HIGHWAY AND LEAD LOCAL FLOOD AUTHORITY RESPONSE TO CONSULTATION ON THE FOLLOWING DEVELOPMENT PROPOSAL

Application number: H20-1114-25

Proposal: Conversion of agricultural building to create two 2 bedroom dwellings with internal mezzanine first floor levels

Location: Barn west of Bells Drove, Sutton St James, Spalding, PE12 0JG

Proposed Site Plan 1:500

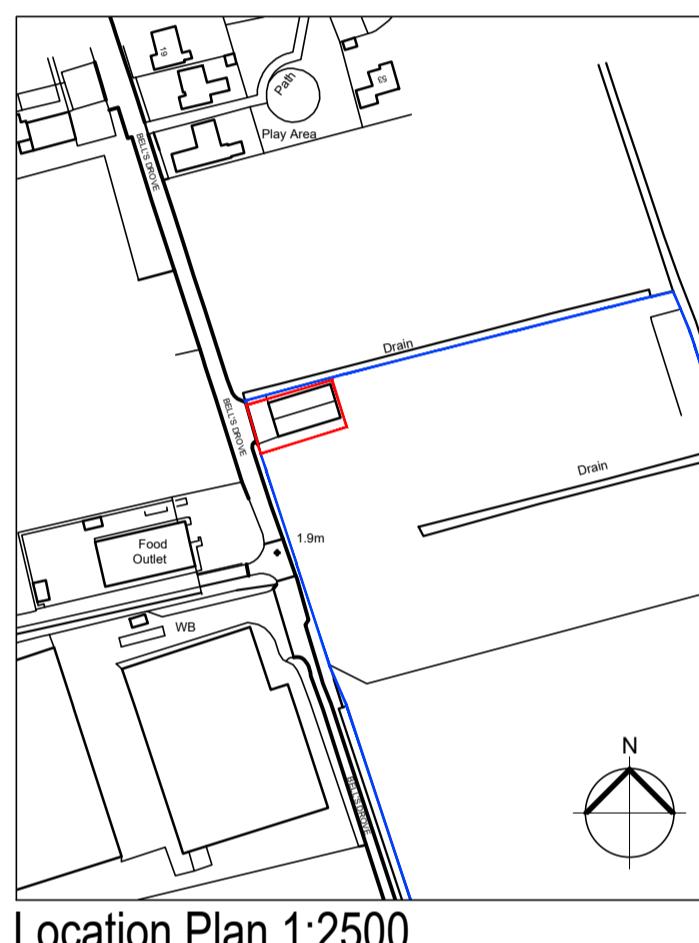
The proposal is for the conversion of agricultural building to create two 2 bedroom dwellings with internal mezzanine first floor levels. Sufficient parking has been demonstrated for the size of the dwellings. The access meets visibility set out in Manual for Streets, although the access will need to be made up to LCC's specification. It is preferred that vehicles reverse into the drive so they can exit in a forward gear. The proposal will not have an adverse impact on the public highway.
